Arun District Council
Arun Civic Centre
Maltravers Road
Littlehampton
West Sussex BN17 5LF
Planning & Building Control General Enquiries
Tel: (01903) 737756 Fax: (01903) 730442
Dx: 57406 Littlehampton
Minicom: 01903 732765
e-mail: planning@arun.gov.uk
website: www.arun.gov.uk/planning

Application No: FP/179/20/PL
Site Address: 7 Ambleside Close Felpham PO22 8NG
Description of works: 1 No 3 bedroom detached chalet bungalow. This site is in CIL Zone 4 and is CIL Liable as new dwelling.

Thank you for your internet representation made on 4th October 2020 which has been recorded as an objection with the comments as follows:

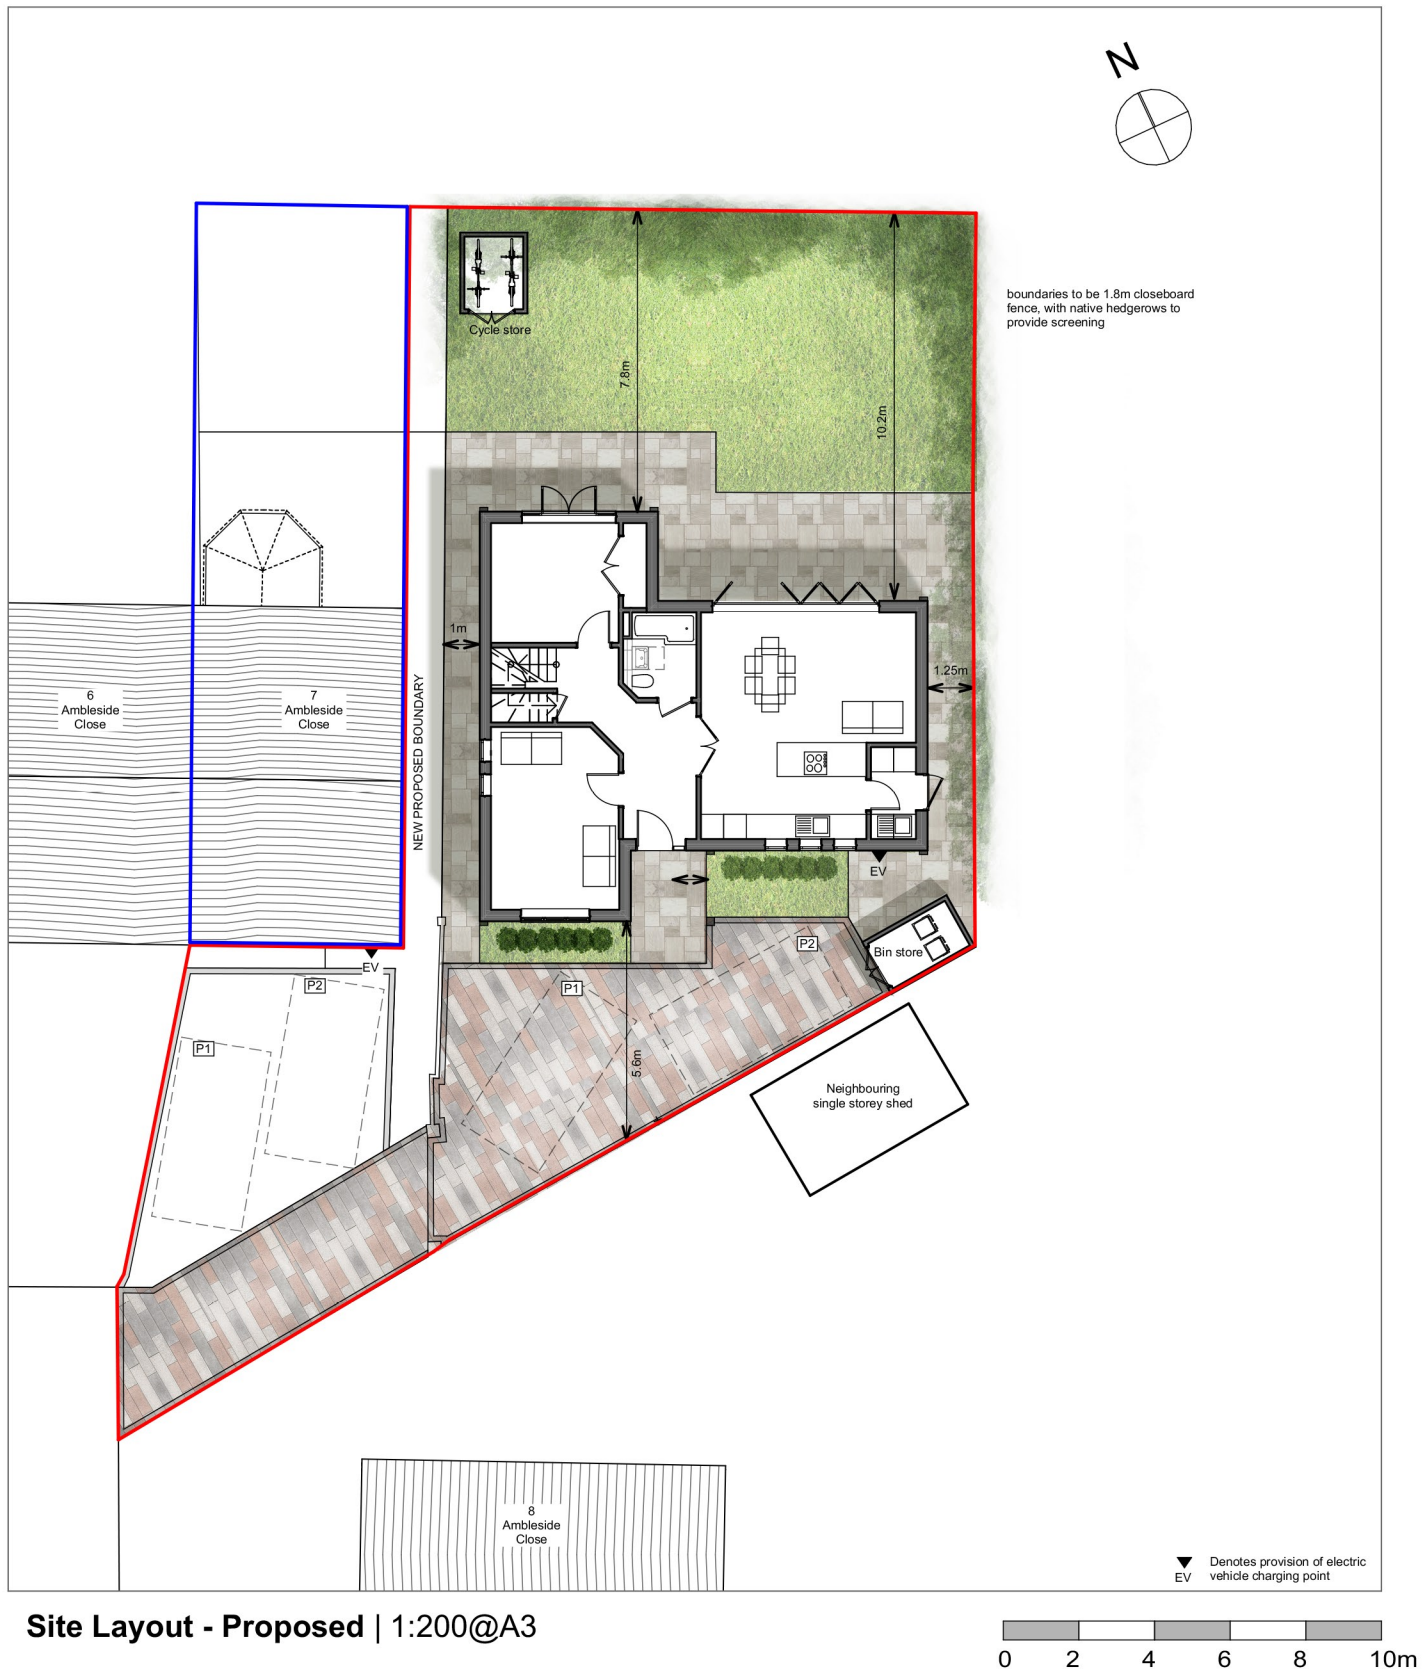
3. I do not think there is adequate space on the proposed plans to facilitate the amount of off-road parking required for the new build.
The small cul-de-sac already gets very congested with cars especially when residents have visitors.

Project/Address	New Build Dwelling 7 Ambleside Close Felpham	Drawing	Proposed Street Scenes
		Drawing Name	4000_PL_006
		Scale	As shown @ A3
		Date	July 2020
Client	Carolynn Bottomley	Drawn By	Ian

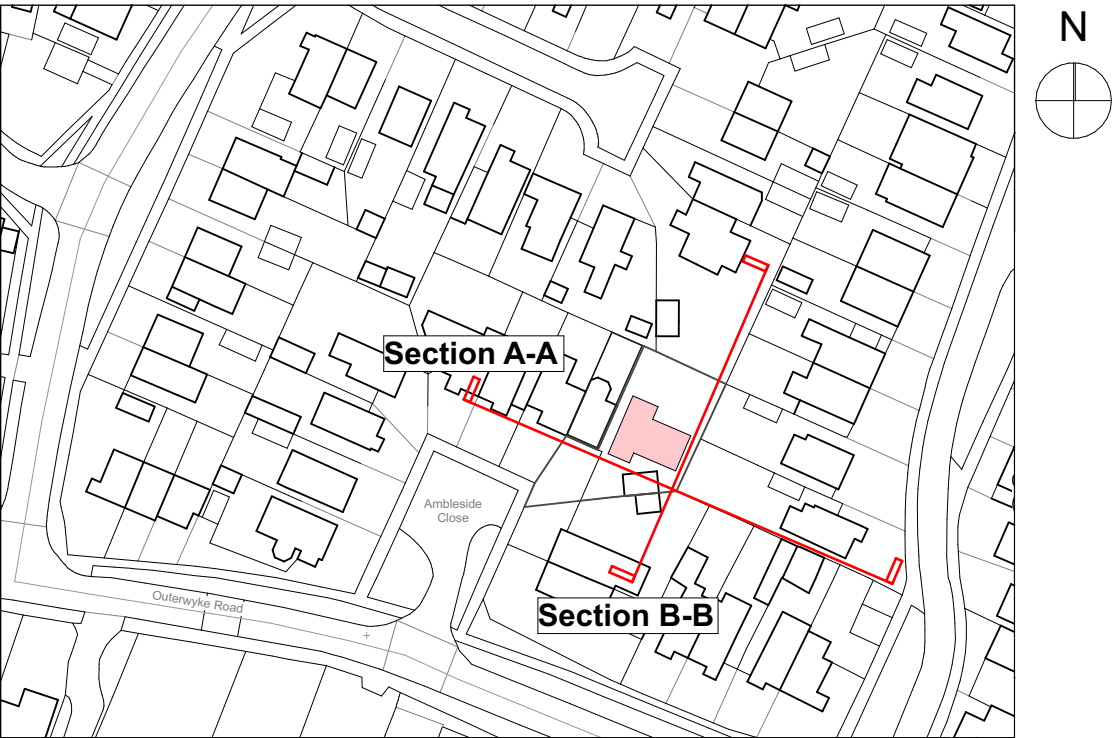
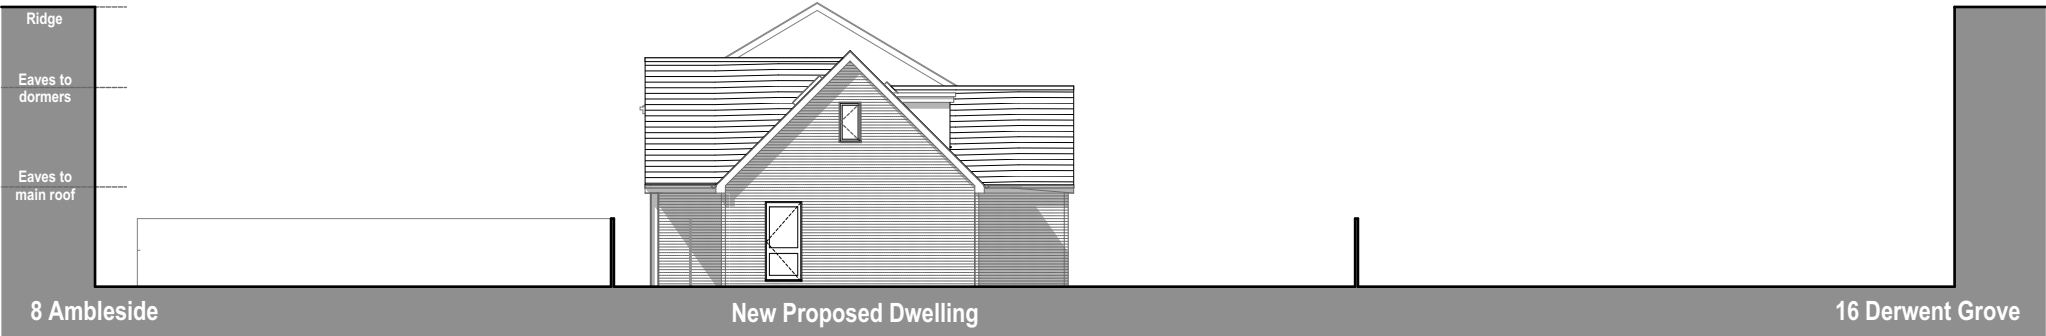
4. The design of the new build is not in keeping with the existing properties and would not blend in and would look completely out of place.
5. There is no yellow notification of the proposed application for planning permission displayed anywhere for residents to view.
